Our ref: DOC19-888026  
Senders ref: SSD-9549

**Subject: Jindera Solar Farm (SSD 9549) - Review of Environmental Impact Statement**

**ATTACHMENT A BCD assessment summary for Jindera Solar Farm Environmental Impact Statement (SSD 9549)**

Figure 1 Location of known Aboriginal sites with the Project area to be Salvaged or Avoided.

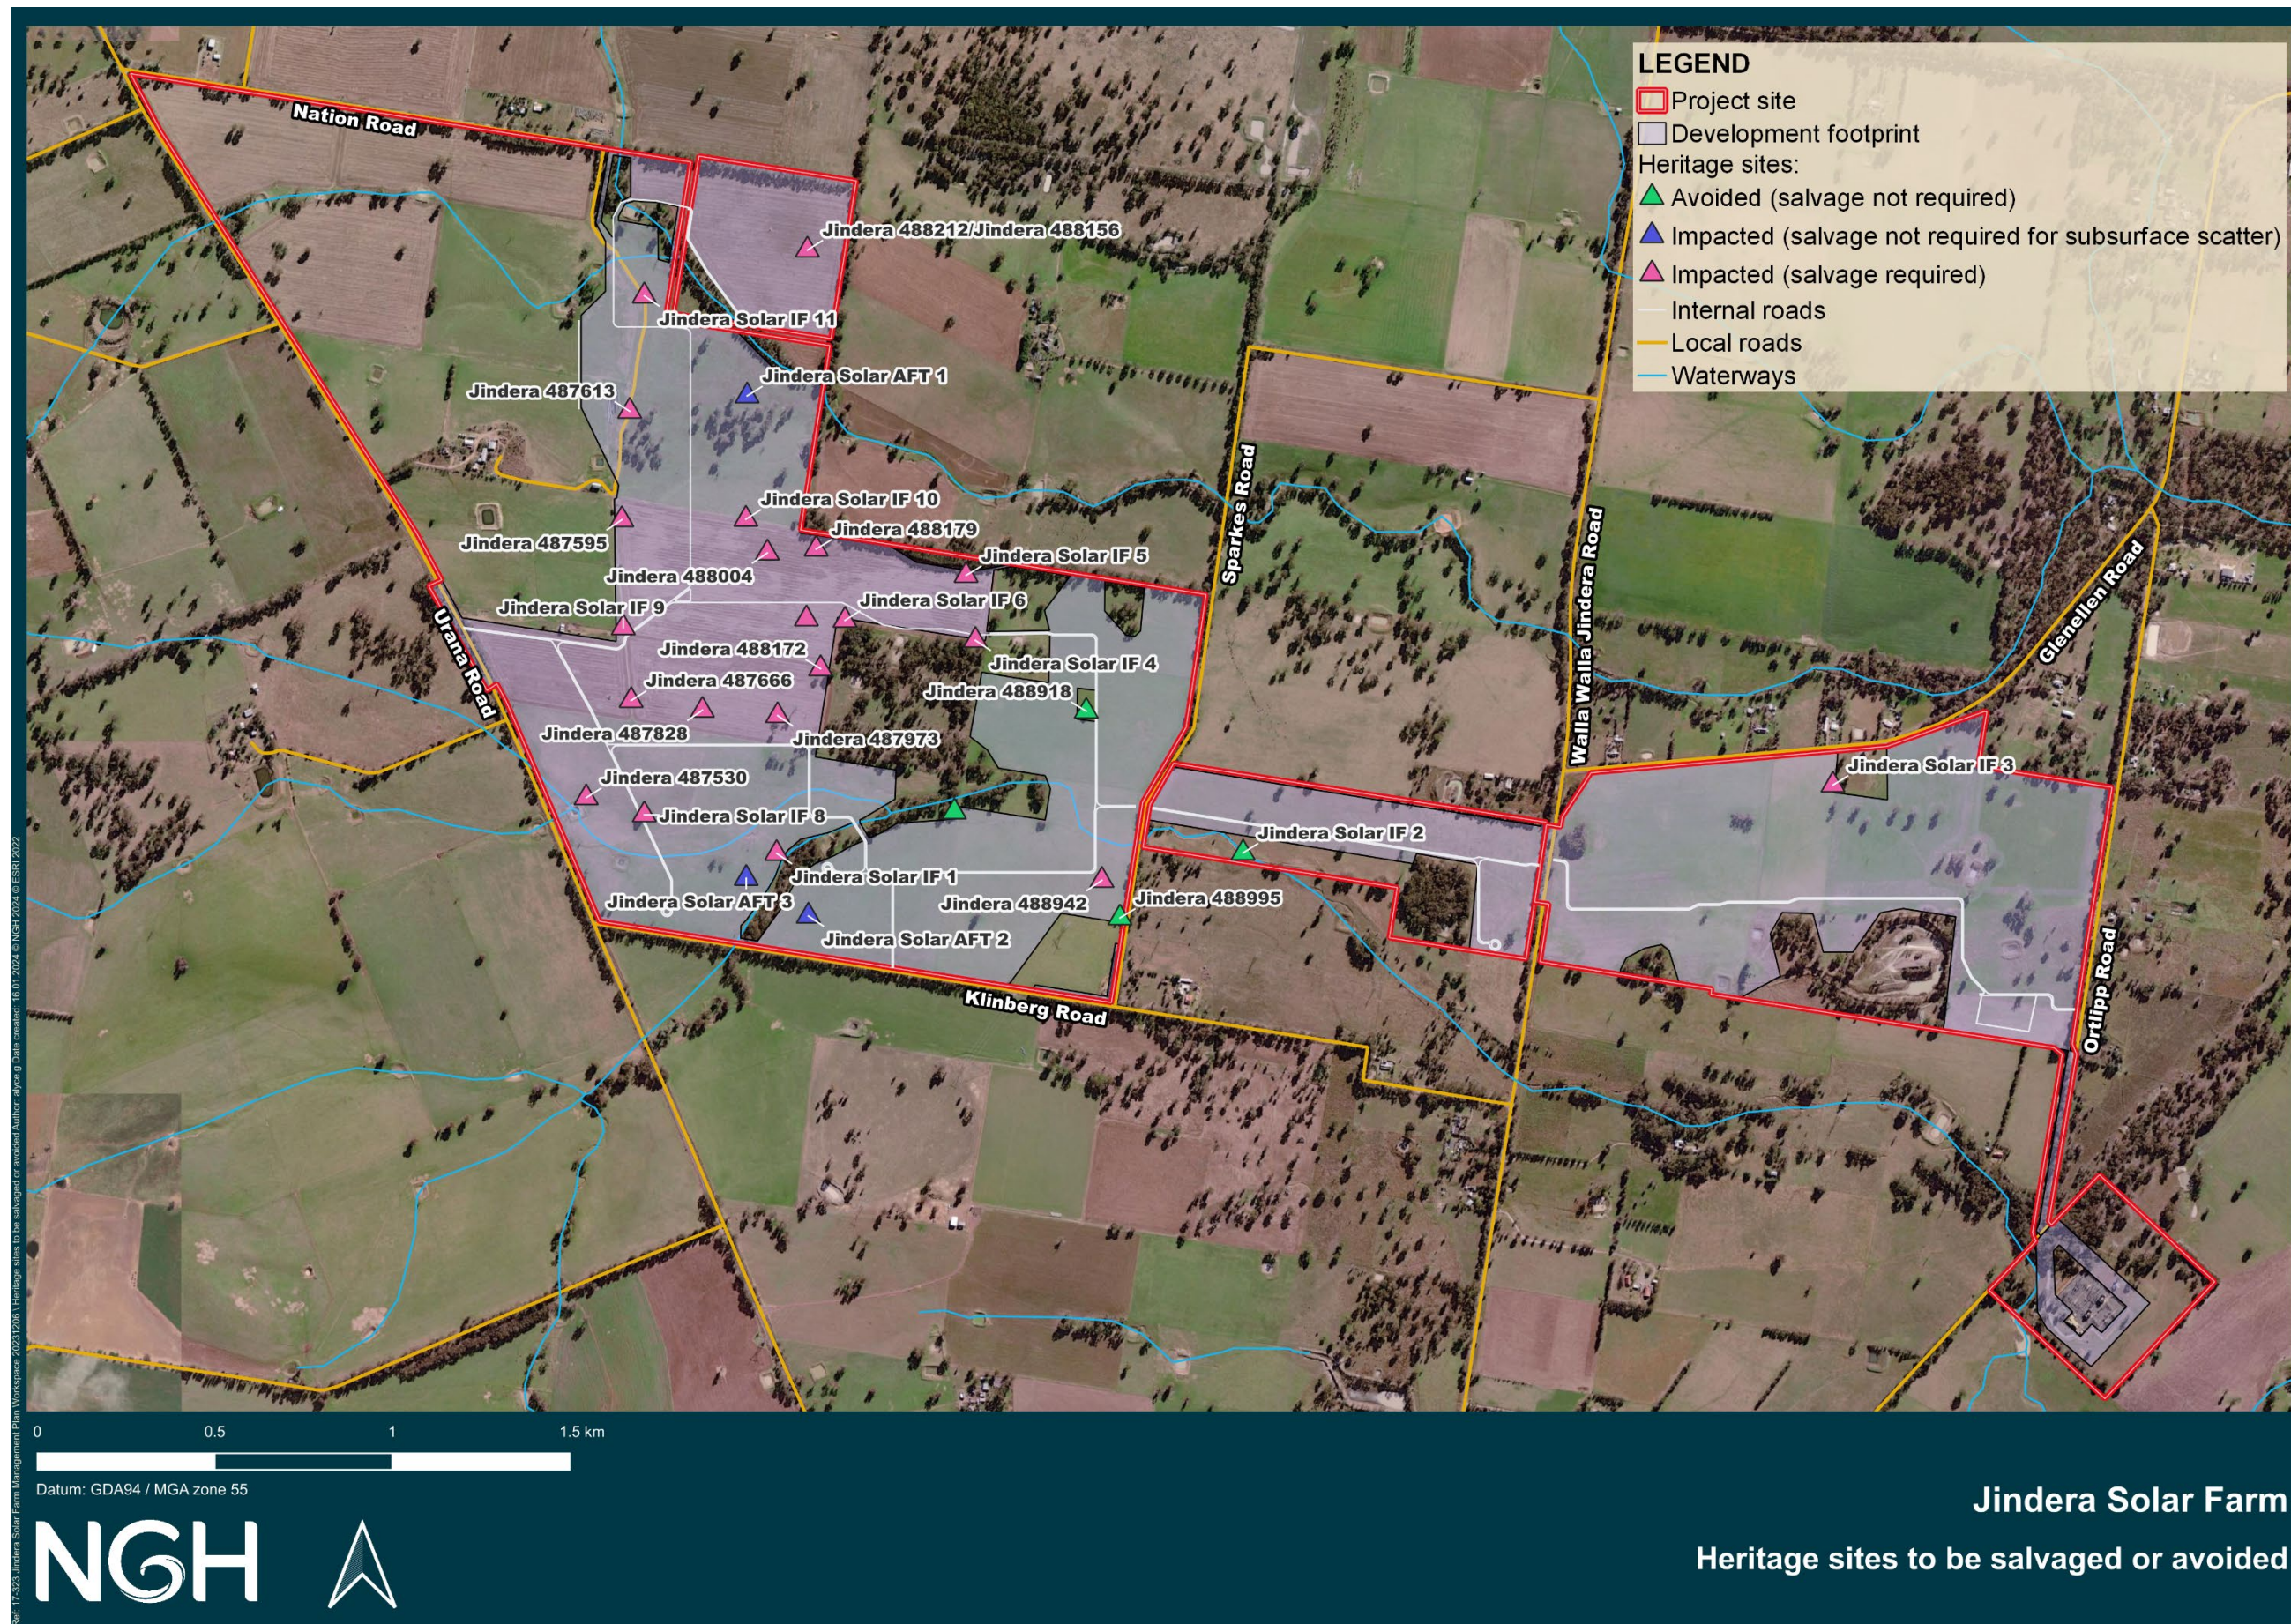
- Maps in the ACHAR show artefact site 55-6-0117 is within the project area. The coordinates on AHIMS place the site several kilometres to the north of the project area. The proponent is requested to notify AHIMS to update the site coordinates in line with the results of the field assessment (issue 2).
